SICEEP PPP – Response to City of Sydney Council Submission

SCALE @ A3	DRAWN	CO-ORD	REVIEWED	APPROVED
1:500	JC	DG	DG	AB
PROJECT NUMBER	DRAWING NUMBER	REV		
AX3688	SK_PP_LA_2055	A

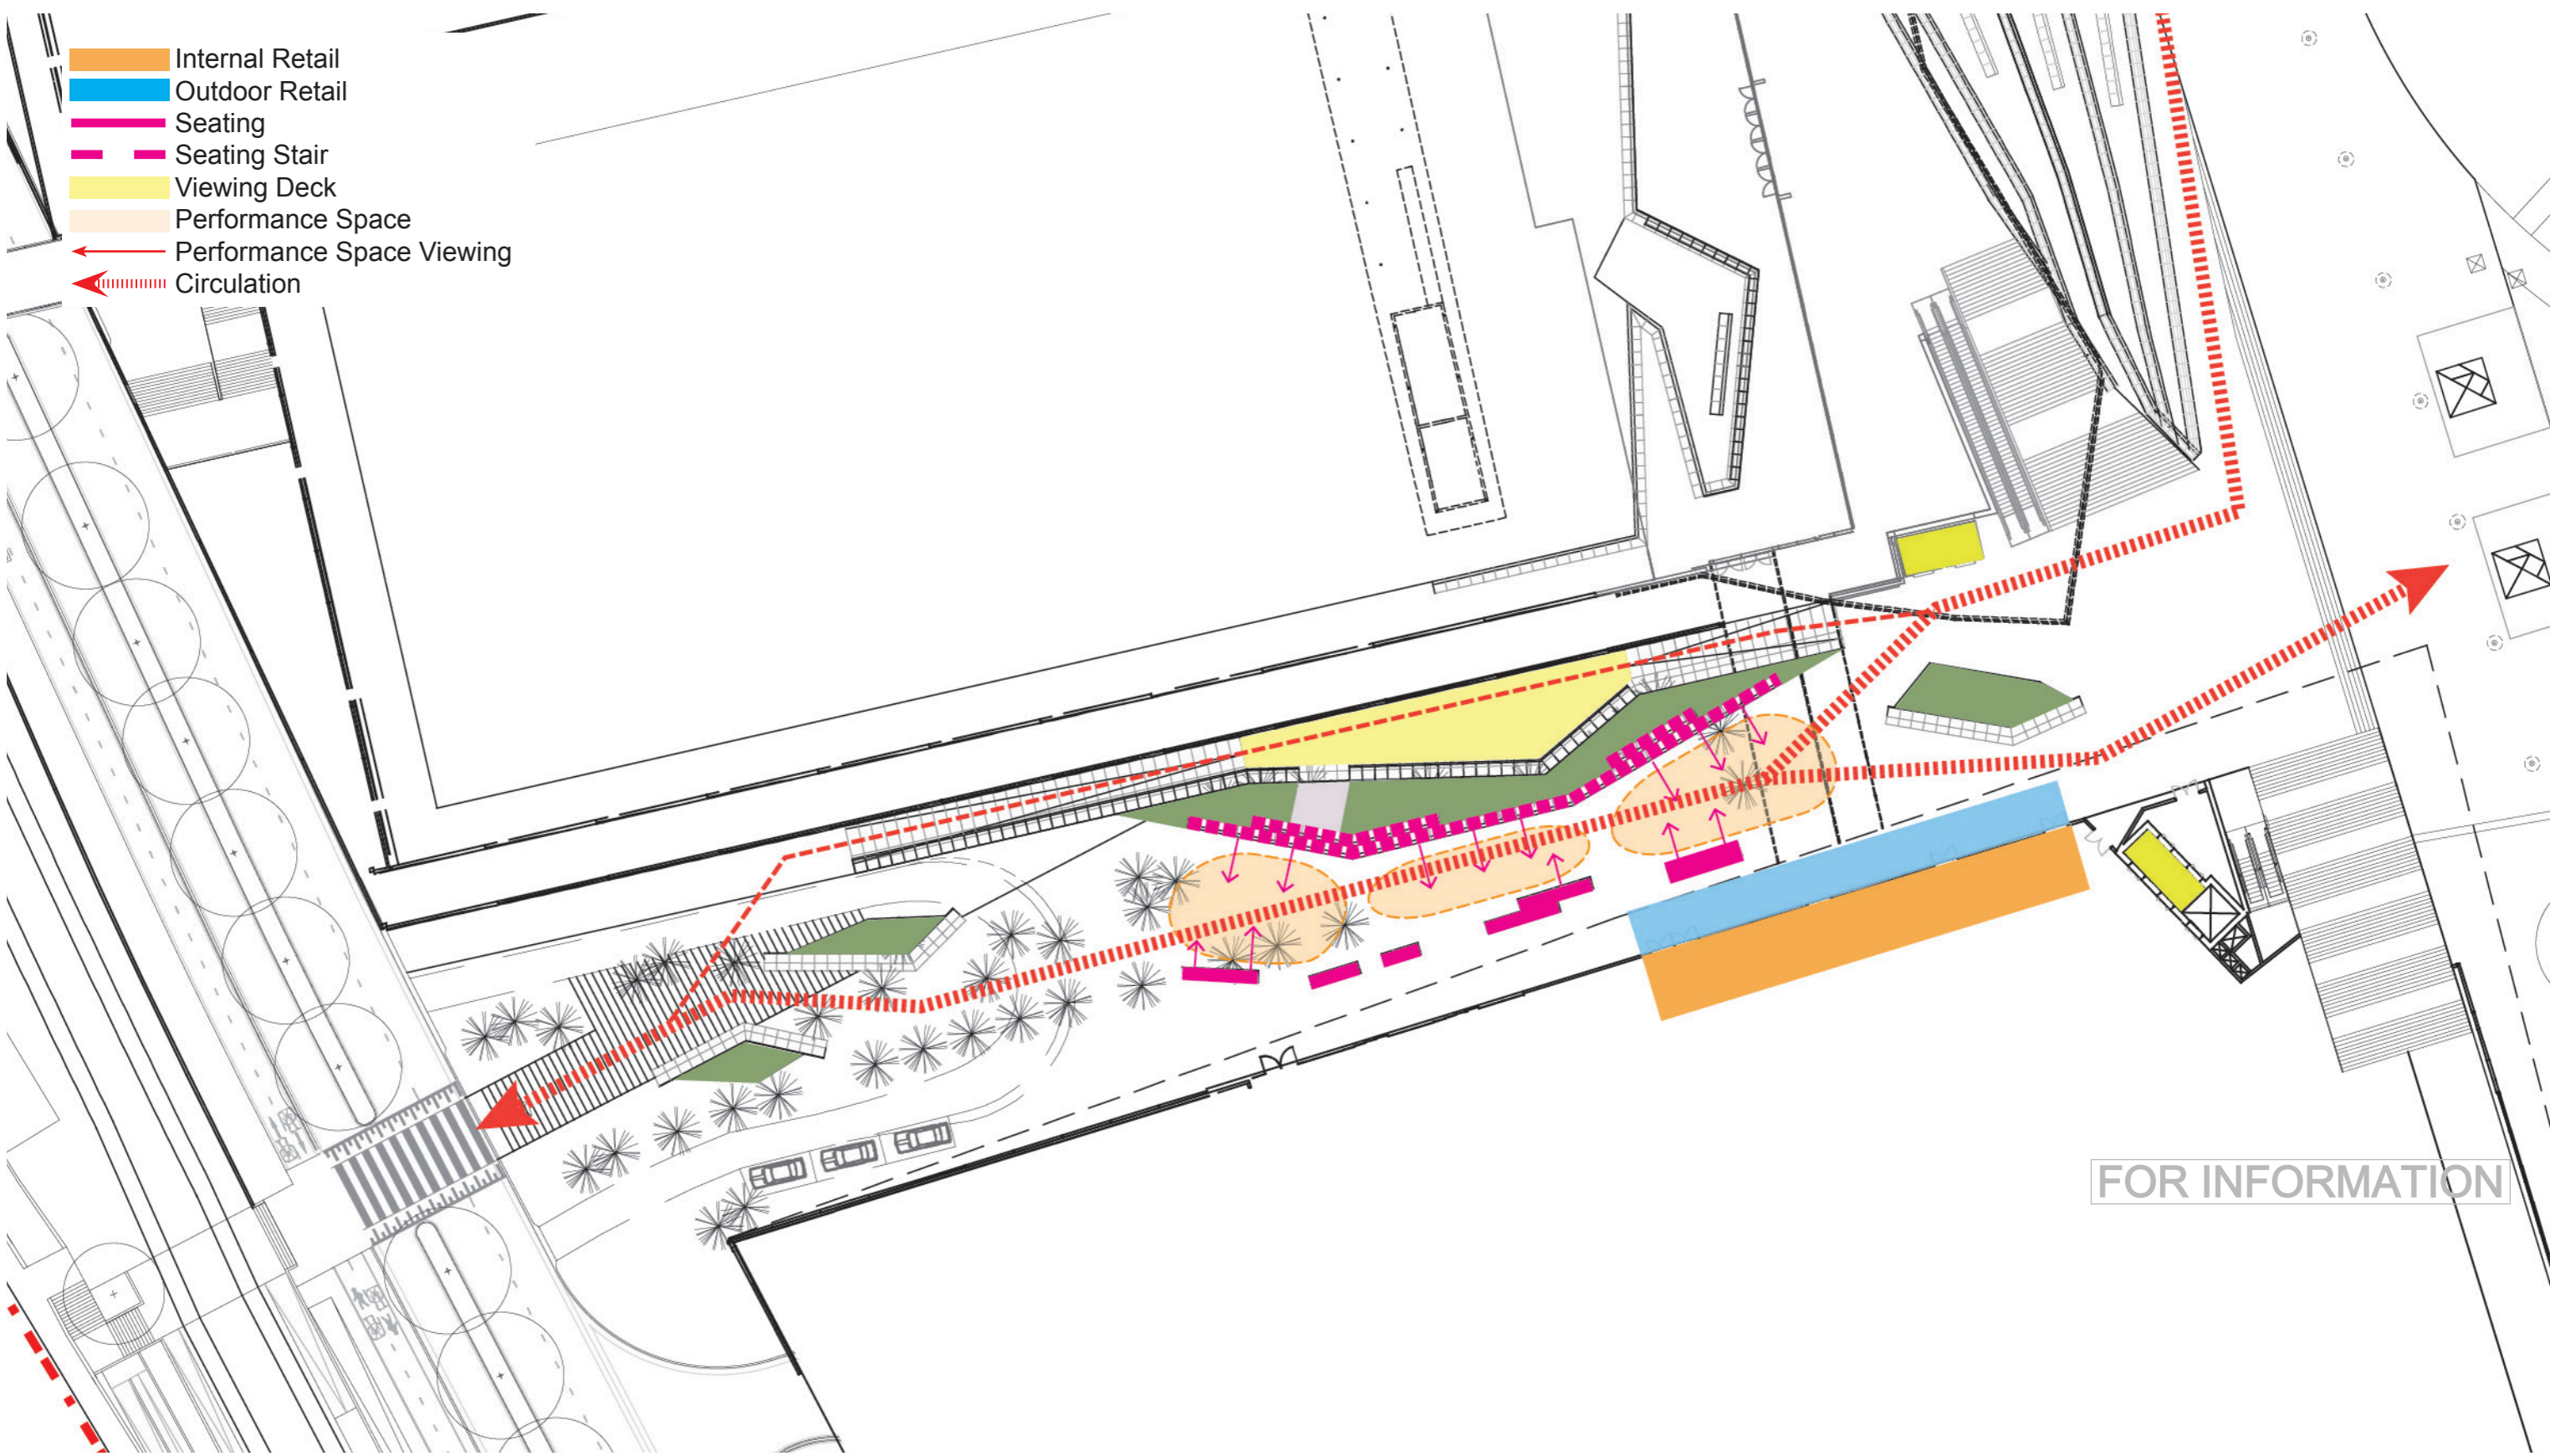
City of Sydney	More active frontage can be provided along the northern side of The Theatre towards Tumbalong Place with minor revisions to fire stair configuration.	<p>In response to the submissions, DHL has reviewed the planning of The Theatre and is not intending to include additional retail opportunities along the Tumbalong Place.</p> <p>The retail along the northern face of the Theatre has marginally reduced to suit the replanning of the Theatre.</p> <p>Activation will be achieved through raised seating terraces and outdoor performance spaces with further activation to include lighting and art along the northern face of the exhibition wall.</p> <p>HASSELL has prepared a Tumbalong Place Activation Plan (refer to diagram</p>

Author	Comment	Response
City of Sydney	The extent of the Exhibition Centre loading dock above Darling Drive should be reduced as much as possible and the underside should be decoratively treated.	<p>SK_PP_LA_2055 at Appendix K and Section 2.2 of the Response to Submissions report).</p> <p>The Exhibition Centre loading dock above Darling Drive has been reduced to the minimum extent needed to accommodate the required truck movements and cannot be reduced any further. The treatment of the loading has been reviewed by DHL (in particular as viewed from surrounding residential dwellings), with improvements being made to the presentation.</p> <p>The external facade of the loading dock has been altered to create a different profile that has more depth to minimise visual impact to surrounding dwellings and is presented in the attached visual analysis.</p>
City of Sydney	The Event Deck should remain an open deck in perpetuity with scheduled community use including active recreation such as basketball. Neighbour disturbance must be managed. The green edge should be reconsidered including the commitment to maintain and manage perspective.	<p>When the Event Deck is not being used for events, it will be an open space area available to the public for activities and will allow for the expansion of the types of events and activities that already occur in Tumbalong Park (such as community events, sporting activities, and cultural events). The Deck will be closed to the public at night.</p> <p>In addition to those comments, it is noted that the Event Deck will remain an open deck with temporary tent structures brought in when required for exhibitions and functions (these will be removed at the end of these events). With respect to the management of the green edge, this will be maintained by the Operator / Facilities Manager.</p> <p>A draft Event Management Plan has been prepared by AEG Ogden (refer to Appendix R) for the operation of the Event Deck. It provides details on public access, frequency of use, hours of operation and noise impacts and noise monitoring. To minimise any amenity impacts, events and functions will be held between 7am and 10pm (including bump-in and bump-out) except for large celebratory events. Low noise events or functions where there is no risk of exceeding the recommended noise level at the nearest residence at Night Time (after 10pm) as recommended in the ENVIA prepared by Aecom, will be finished by 11pm.</p>

TUMBALONG GREEN CHANGES

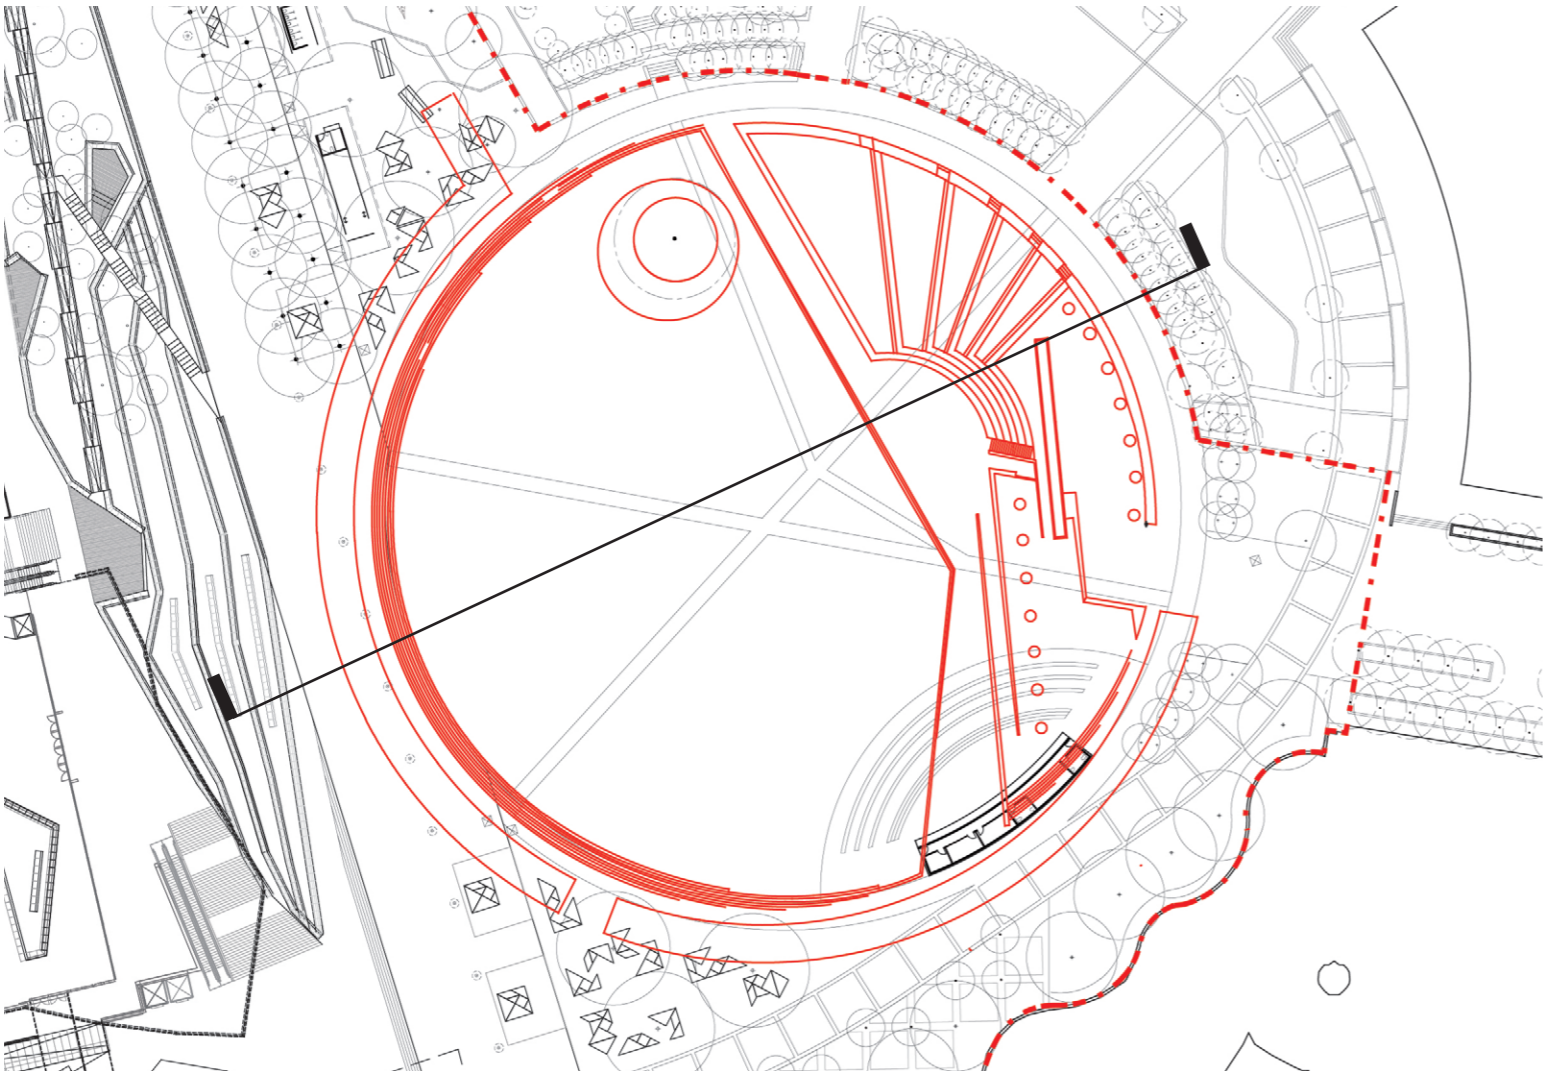
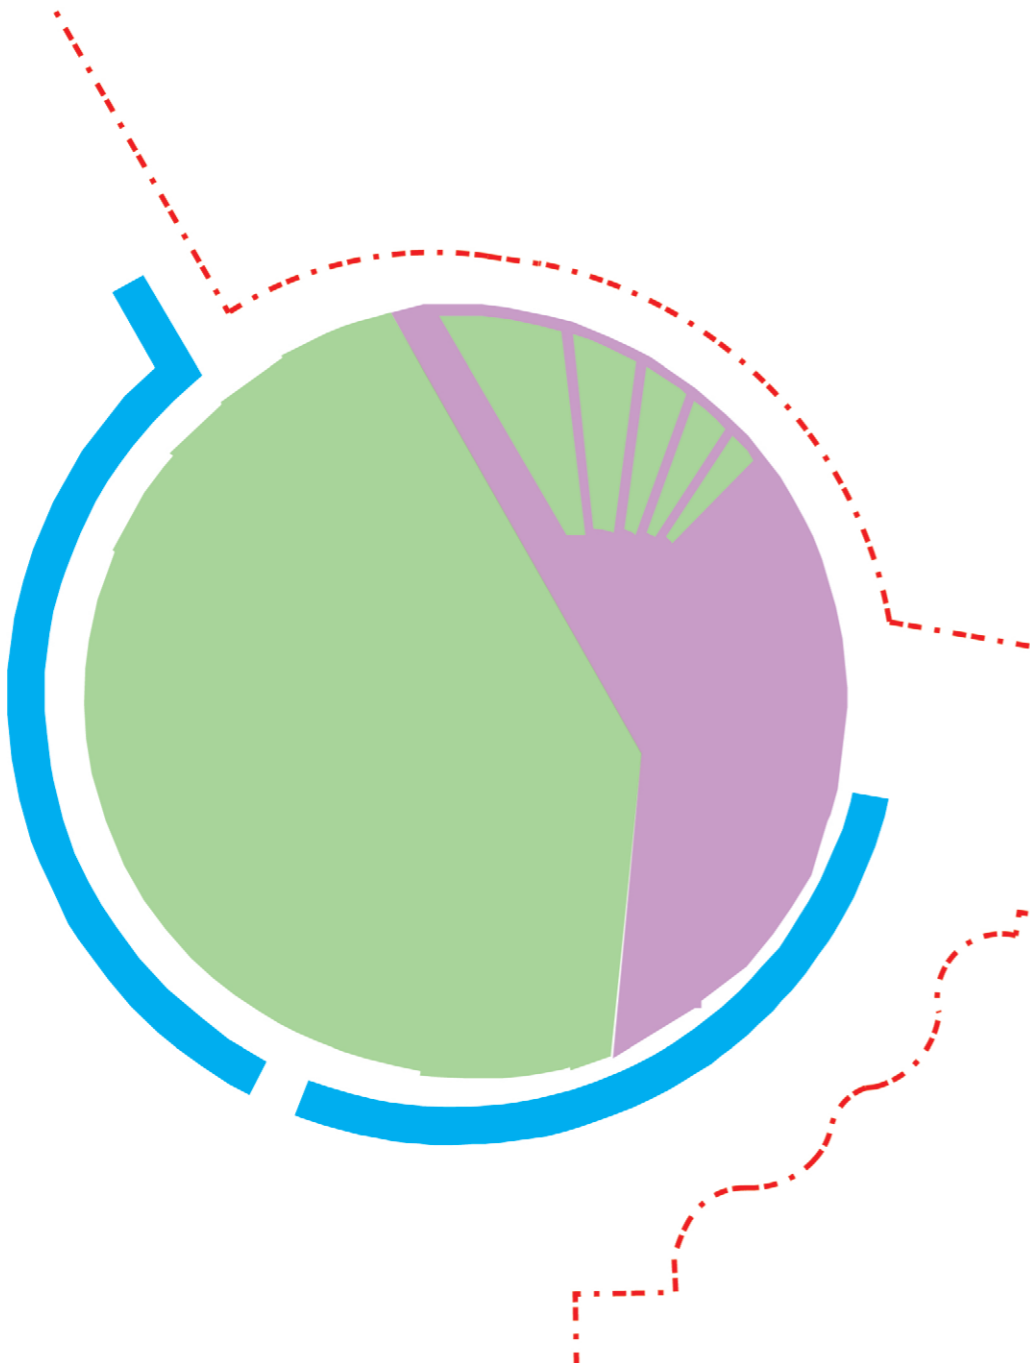
City of Sydney	The southern pathway around Tumbalong Green should have its own geometry and widen at The Boulevard to cope with likely pedestrian demands.	<p>DHL concurs with Council's comments and will address this further during design development.</p> <p>HASSELL has prepared a diagram for the Tumbalong Green Pedestrian Network (refer to diagram SK_PP_LA_2061 at Appendix K, and Section 2.5 of the Response to Submissions report) which gives an indication of the revised geometry.</p>
City of Sydney	The Exhibition Centre and Entertainment Centre forecourt should provide at-grade surfaces including ramps if necessary.	DHL confirms that a ramp has been provided and has been documented on the revised drawings at Appendix H .
City of Sydney	(a) Materials and finishes are to be discussed with the City in further workshops.	DHL agrees with CoS's suggestion of further workshops to finalise materials and finishes.
